From: Sue Howell
Sent: 28 February 2019 14:49
To: Planning.Responses
Cc: Michael Eastham
Subject: FW: Planning Consultation on WA/99/18/DOC

Further to submission of revised landscape details contained in dwgs CSA 3823-101-111 Rev B in relation to Condition 9 of this application WA/99/18/DOC I can recommend the following:

APPLICATION NO: WA/99/18/DOC

Site Address: Land East of Tye Lane Walberton Arun

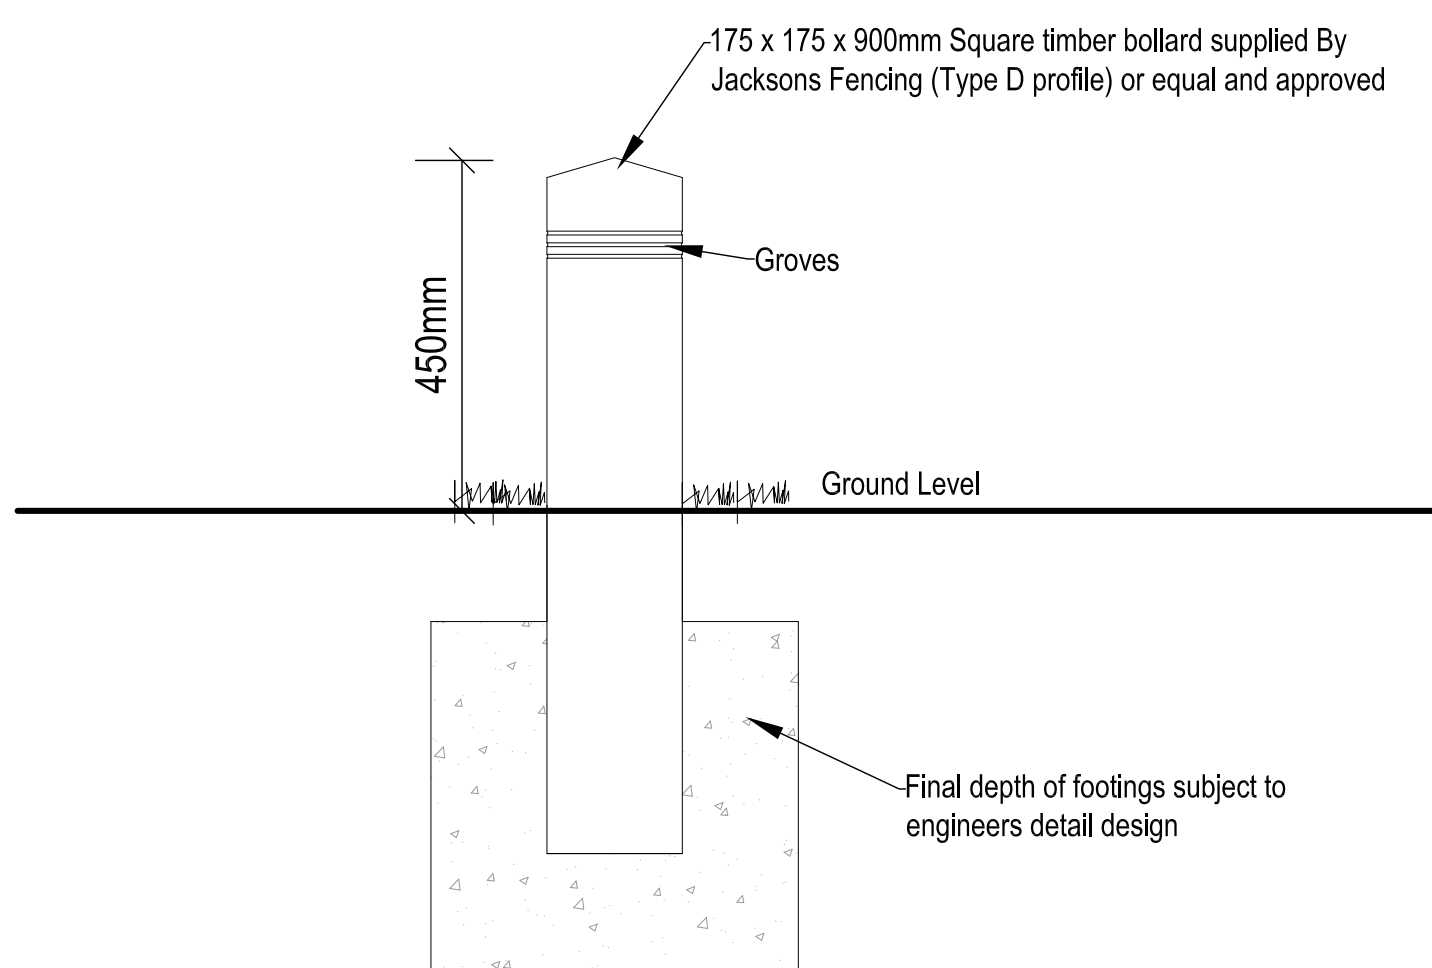
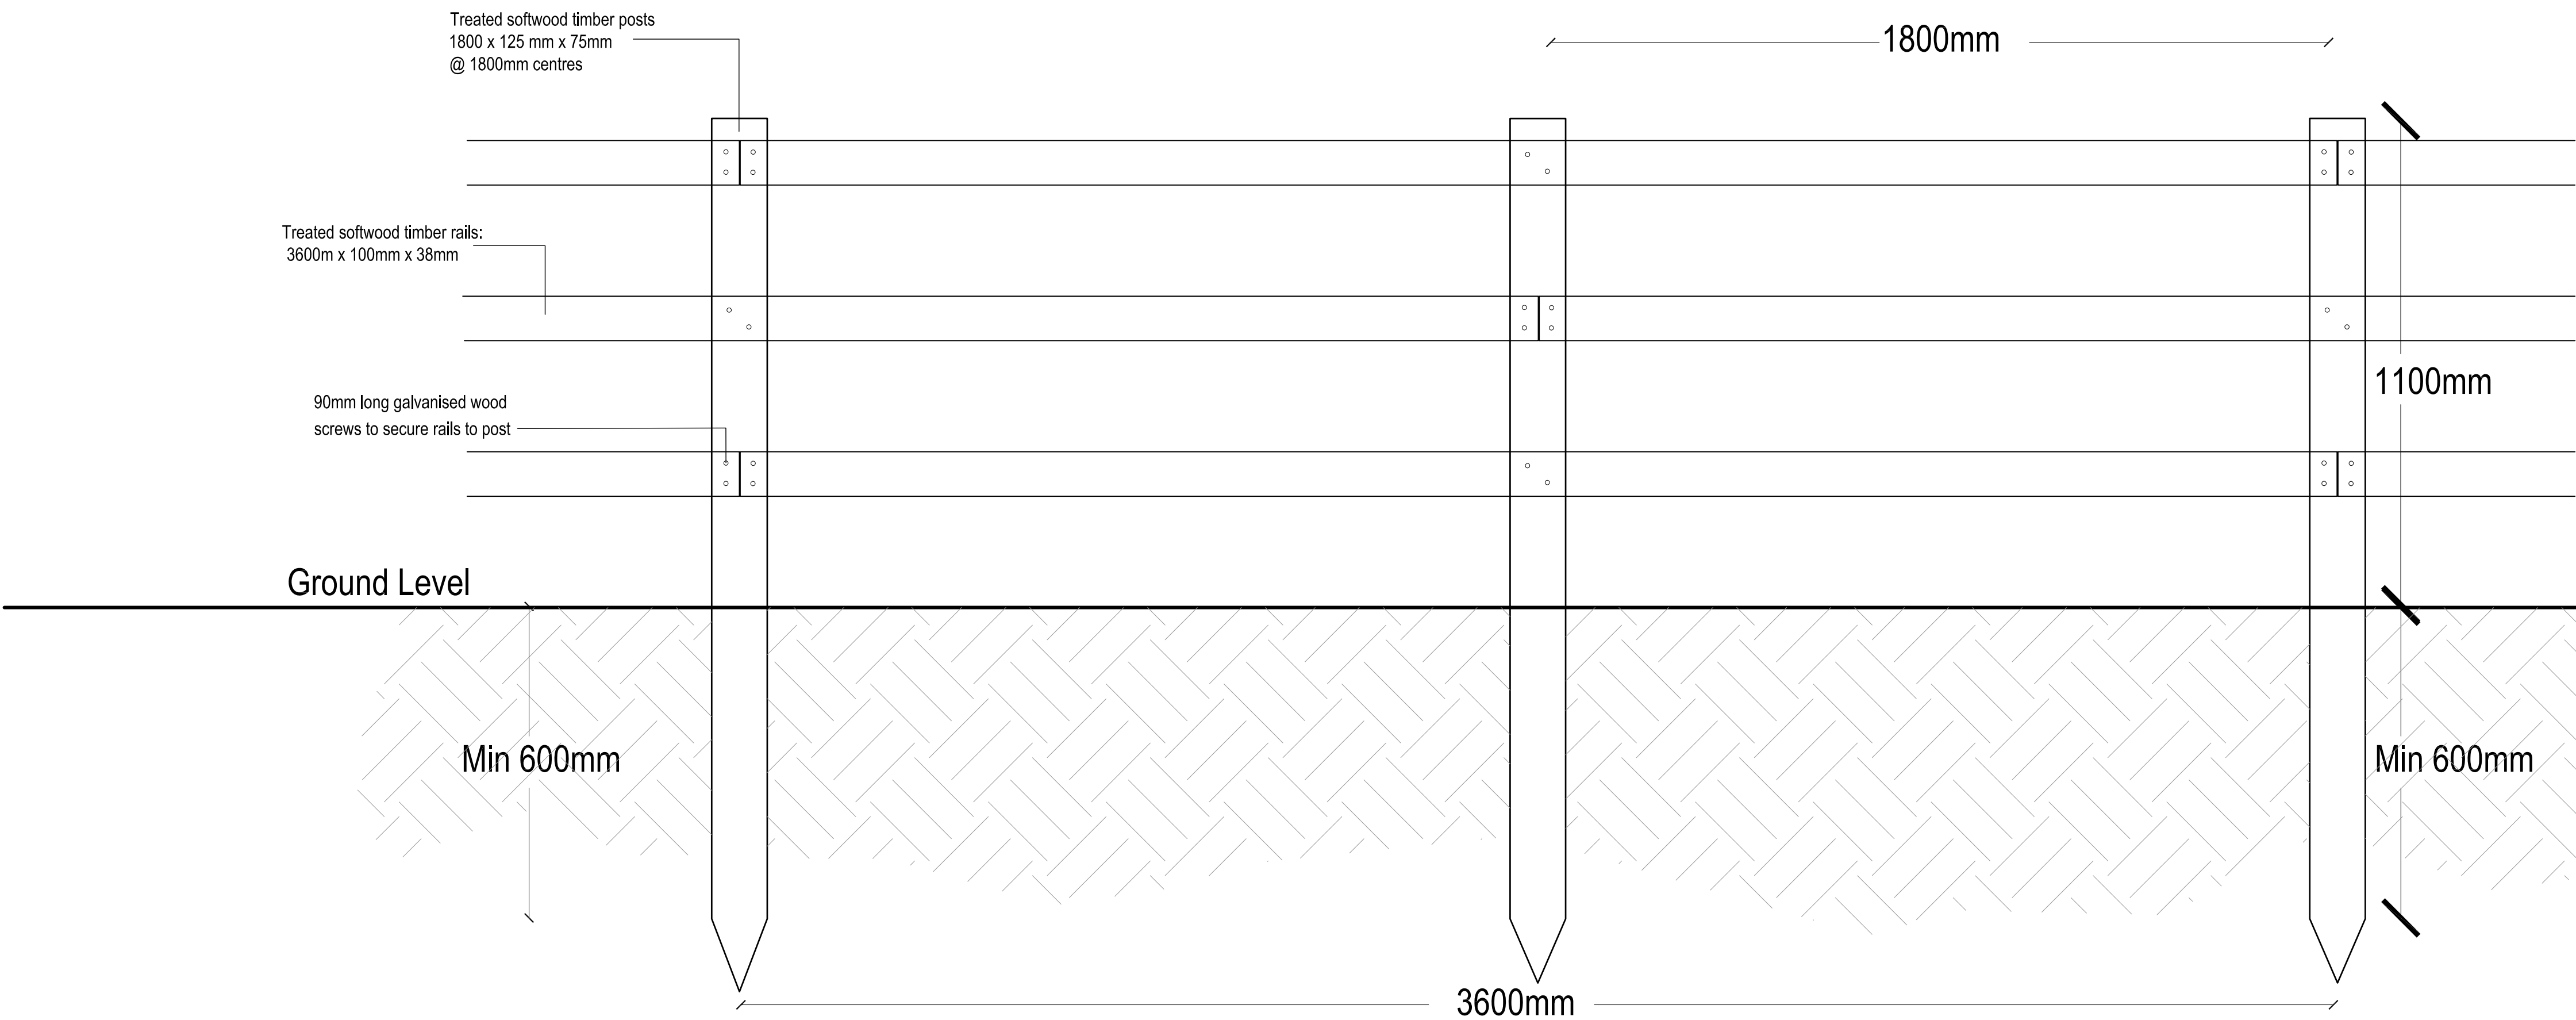
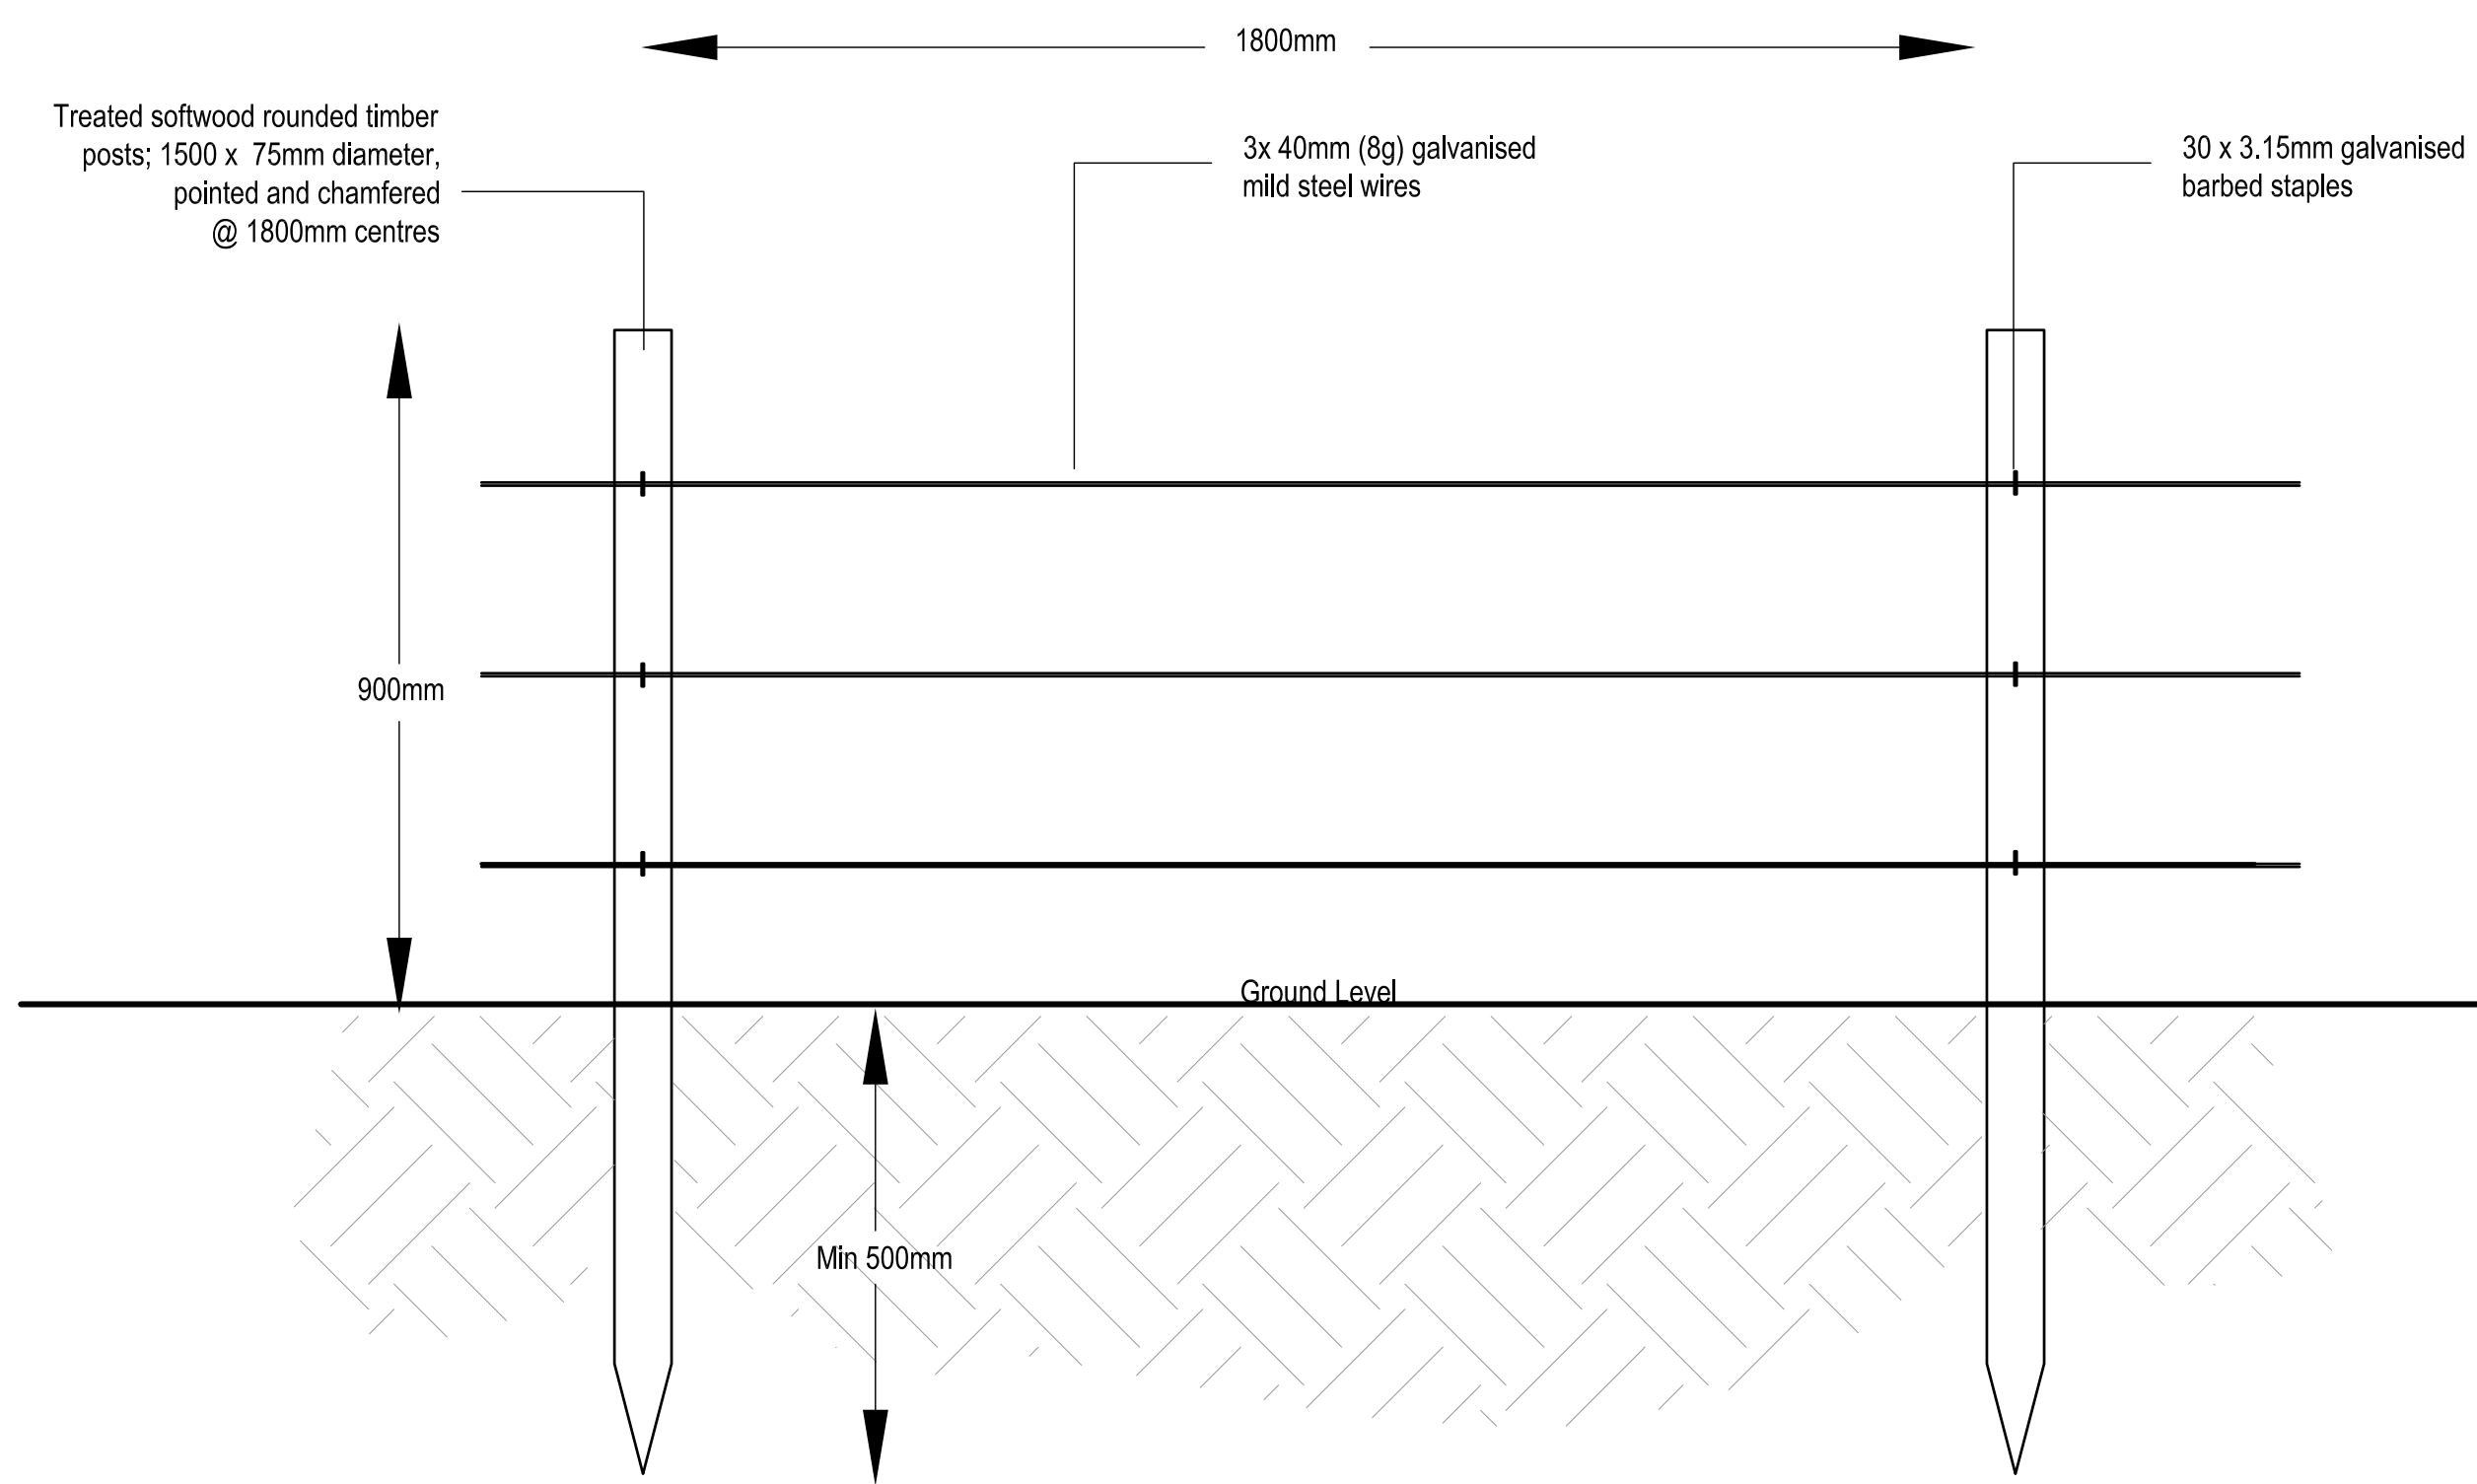
- II. Details re height, design and type of boundary treatment have been provided.
- III. Crown spread and location of trees to be retained have been shown in location within masterplan and detailed landscape drawings and the topography in which these sit.

I would therefore **recommend discharge of Condition 9** landscape details contained in this reserved matters application WA/95/18/RES following outline consent WA/44/17/OUT.
